June 23, 2022

Re: Plummer Residence

In response to recent City of Mercer Island Comments with respect to protection of trees on site and those offsite that could potentially be affected by site development I have prepared the following response to the following item No. 8.

SHEET:
C-2

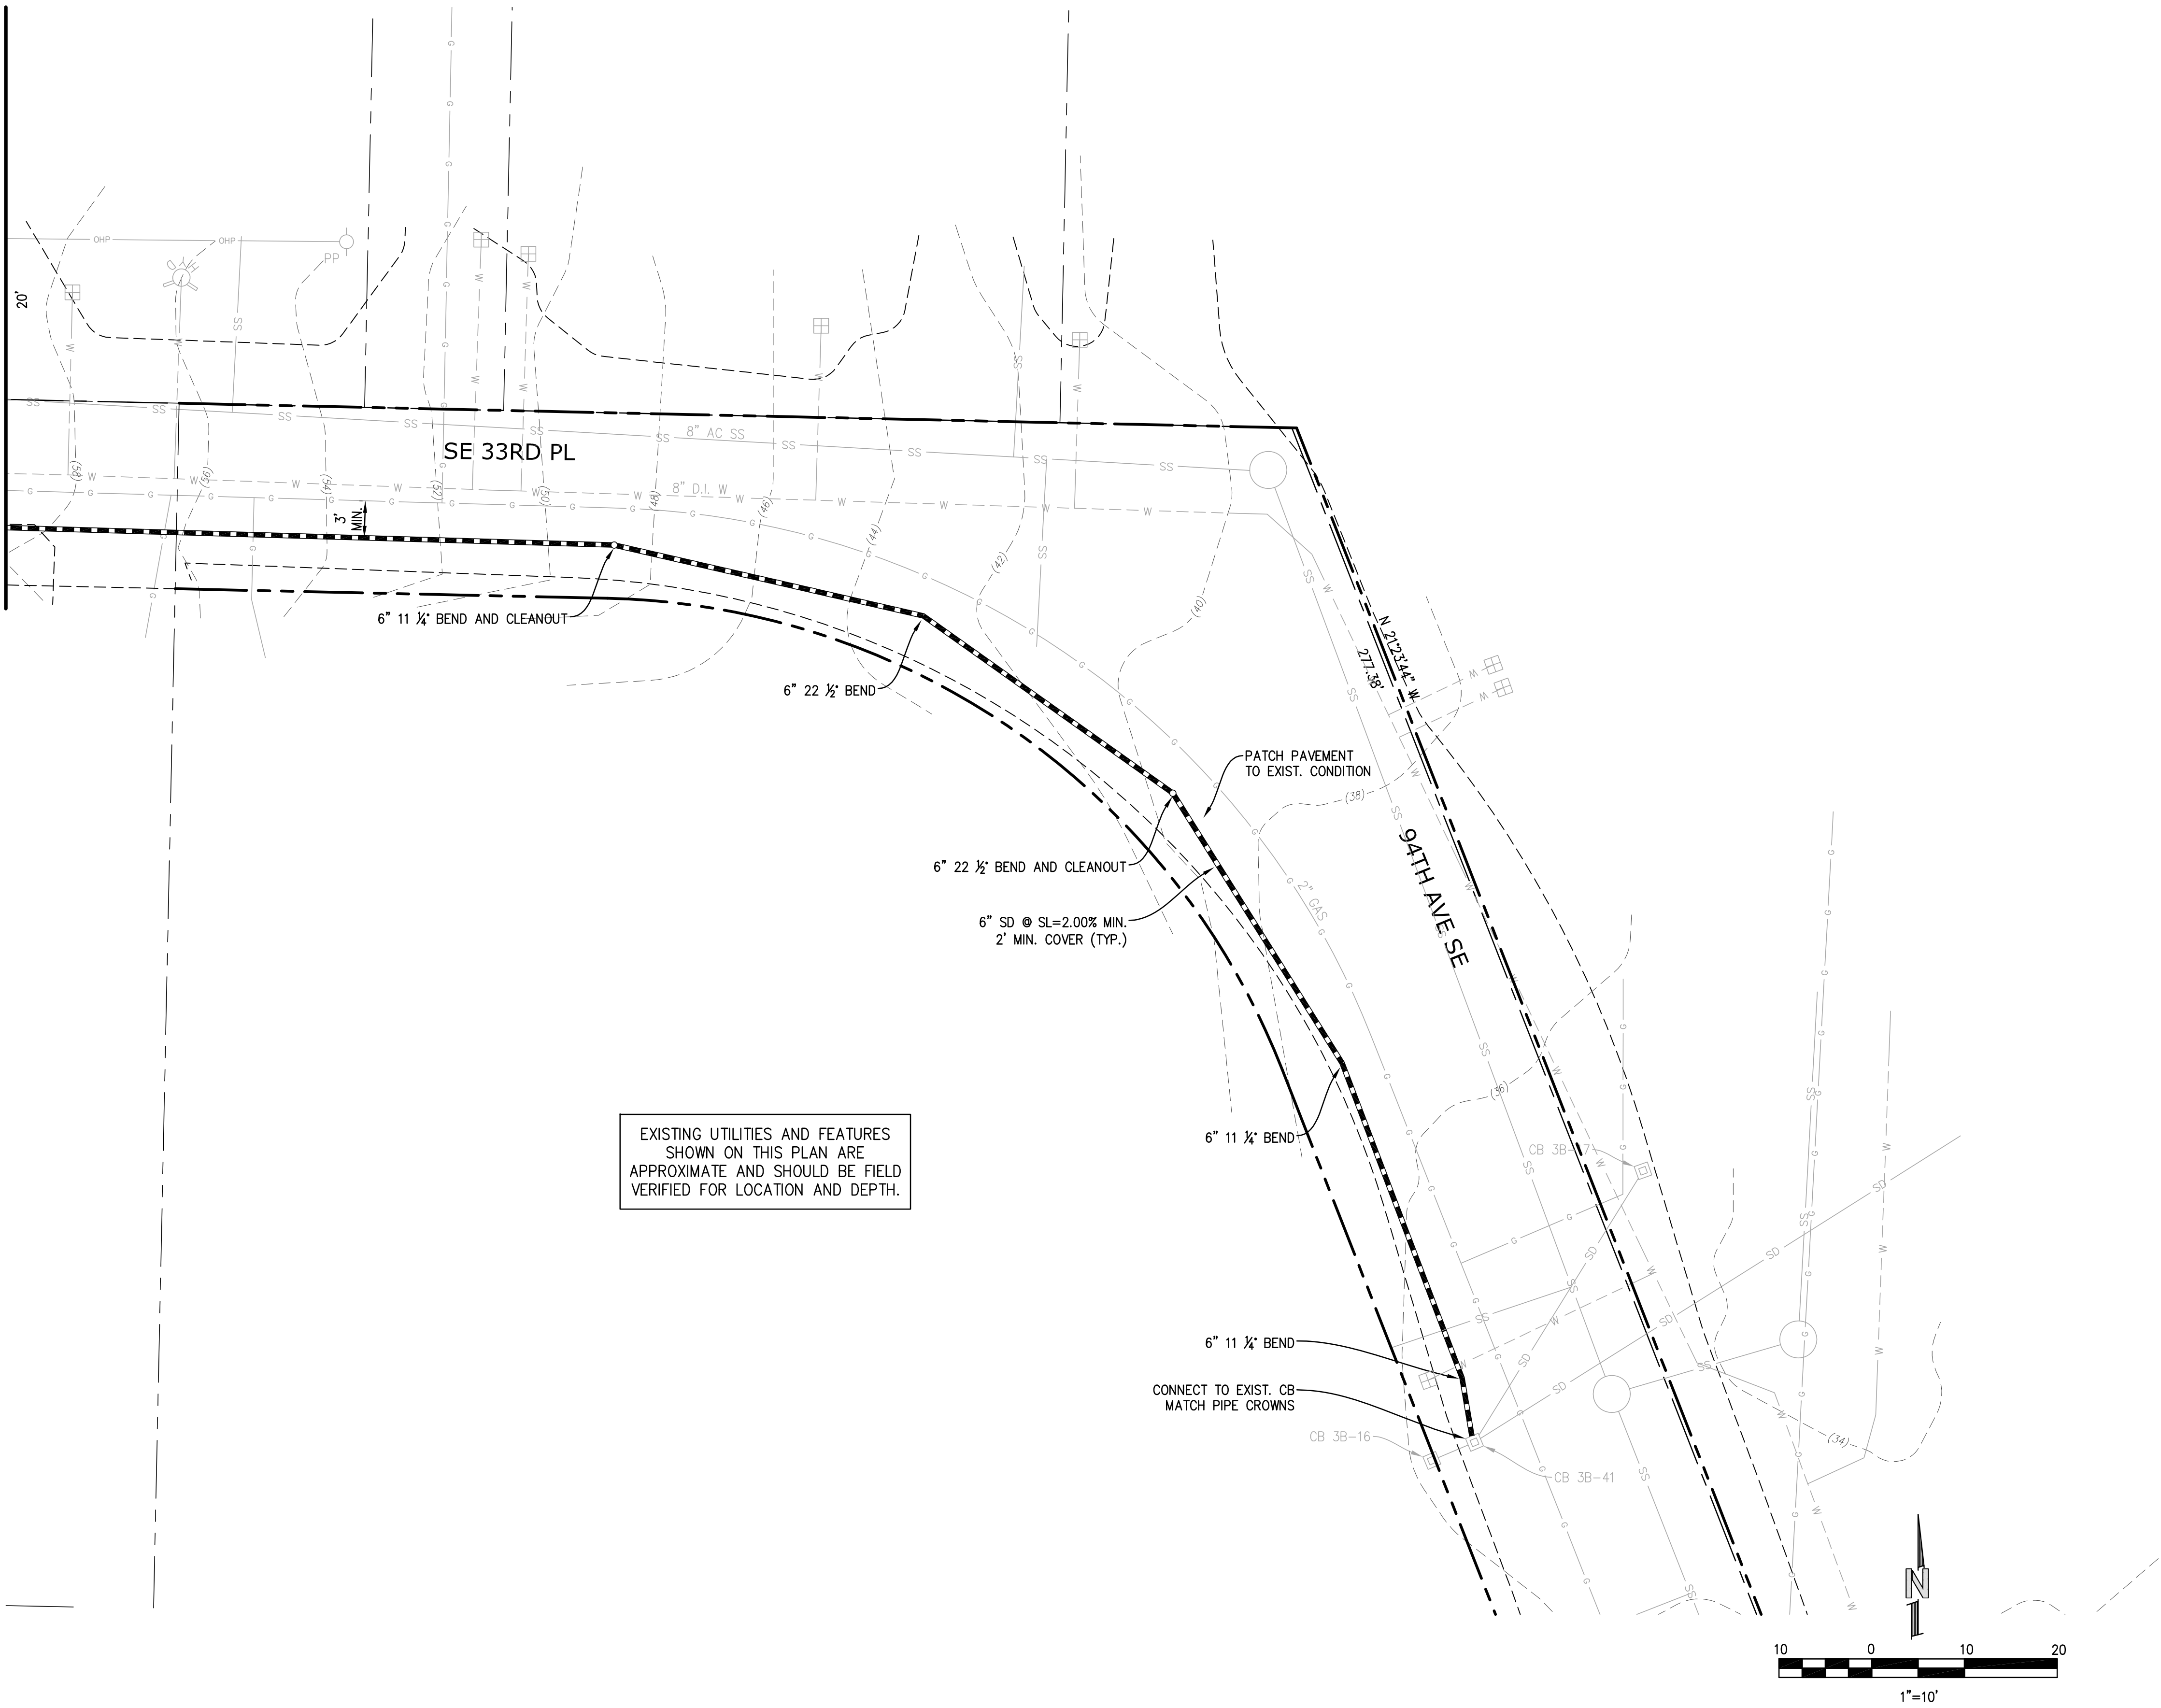
*8. (From Intake for Civil/Architect/Arborist) Grading is shown within 7' of exceptional tree 1 that has a dripline of 24'. Have the Project Arborist review and cite plan sheet C-2. Provide air excavation analysis at the location of any area of excavation within exceptional tree 1's dripline. Arborist will ensure the tree will not decline in health because of this work according to 19.10.080. Use this opportunity to excavate the to be abandoned the existing sewer, storm, water with air excavation (with air excavation). If the proposed encroachments into the dripline will damage the tree long term, those encroachments including the In-Ground Trampoline and house need to be modified or moved. Tightlining the drainage would also limit impacts to the saved trees. An Arborist memo will be required if grading and other encroachments into saved trees driplines are not moved. "*

The attached revised site plans do not propose hardscape installation near trees 5,6 or 7 or nearby offsite trees along the southwest side of the property. As well, no new sewer line installation will be run under or near trees No. 1 or 2.

Air excavation of the root zone around Tree No. 1 will be employed at the excavation line of the proposed house footing. The project arborist will be on site to inspect roots, if any encountered and will advise the contractor on proper root damage mediation including cutting the exposed roots cleanly at the excavation line, application of moist burlap over the cut ends until native soil back fill can be installed.
